**Application by London Luton Airport Ltd for Development Consent for the Proposed London Luton Airport Expansion**

**Planning Inspectorate Reference TR020001**

**Consultation Seeking Information from the Applicant and Interested Parties**

# M1 Junction 10 Intervention Assessment Report

Drawing title: **M1 J9 TO J10 NORTHBOUND & DIVERGE**

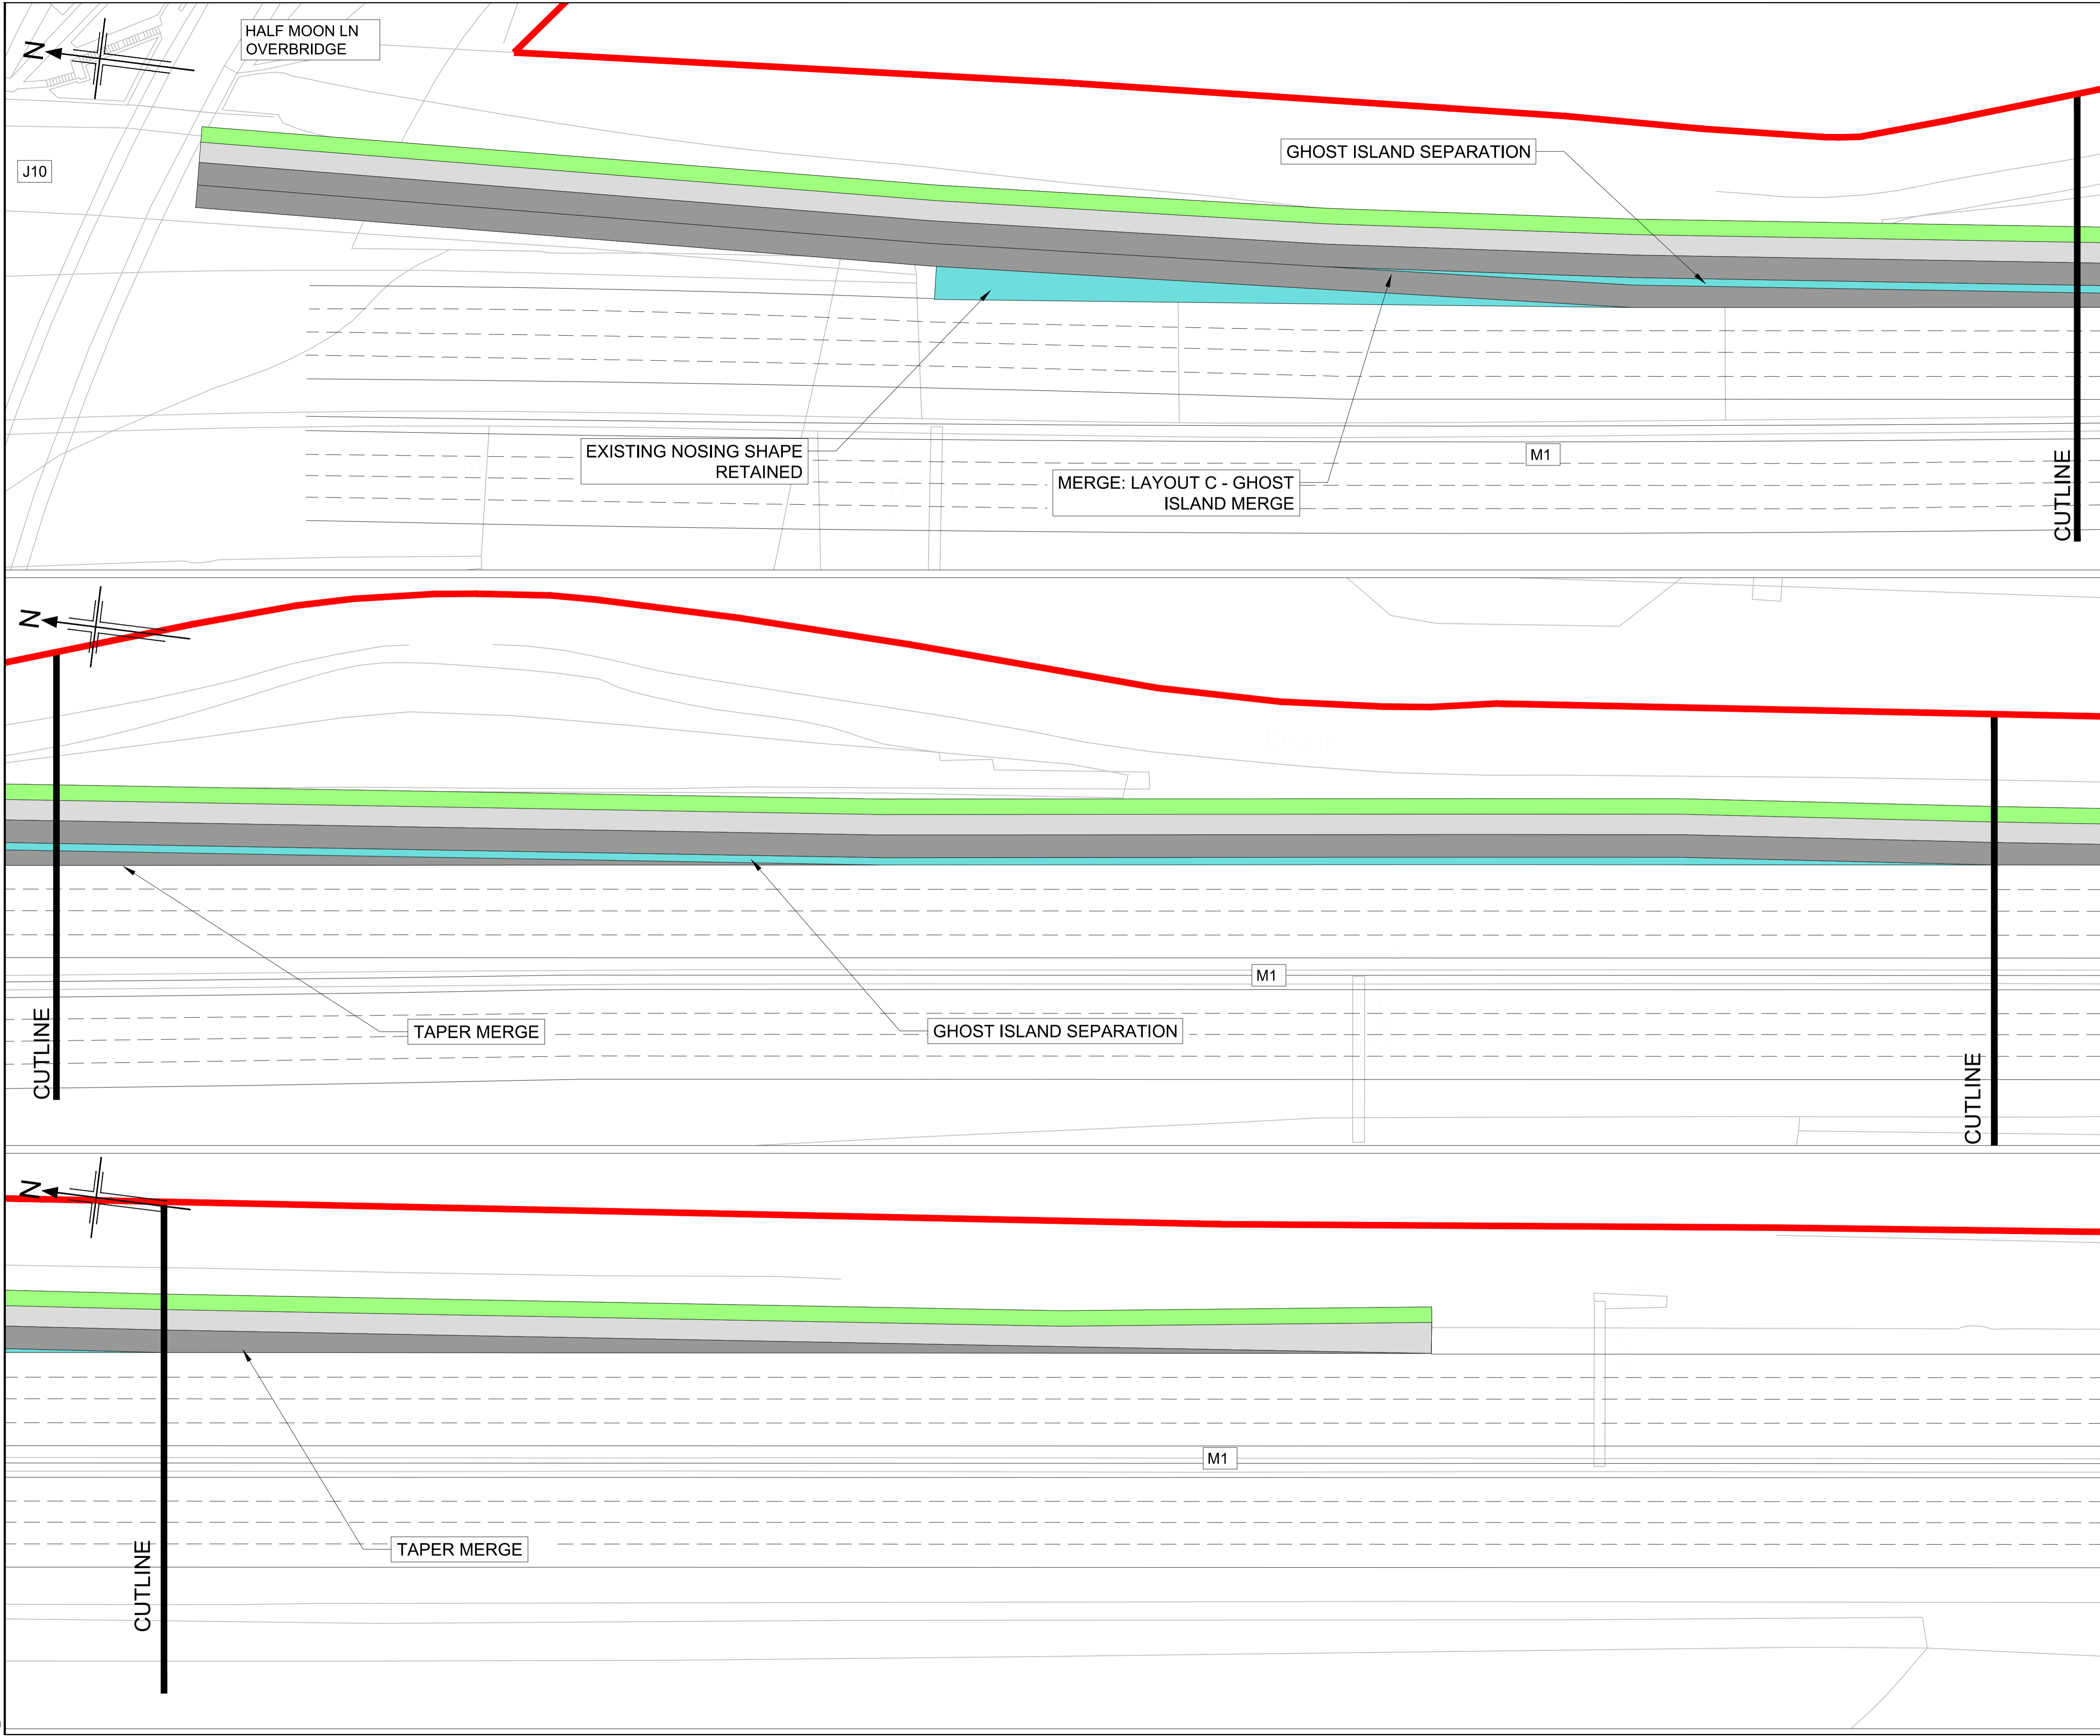
8. Based on the post COVID-19 VISSIM testing, it is clear that the proposed northbound diverge would provide sufficient capacity to safely accommodate the growth in demand for movements to Luton Airport by removing the lane drop on the northbound carriageway on the M1 and enabling junction 10 to accommodate the released traffic.

9. Due to the limited network coverage of the VISSIM model, it is difficult to draw definitive conclusions on the performance of southbound merge. However, the need for an intervention to increase capacity at the junction 10 southbound merge has been identified. This capacity upgrade would improve safety and operational performance resulting from longer periods of free-flowing traffic on the SRN. It is advised that a revised strategic model and a VISSIM model that covers both the M1 junction 10 and junction 9 is prepared if the scheme is to be developed further. This would enable the southbound intervention to be fully assessed.

To ensure the safe operation of the network, National Highways requires that the appropriate mitigation identified in this report, or similar, is secured in the DCO, as set out in National Highway's final Deadline 11 submission **[REP-11-073]**.
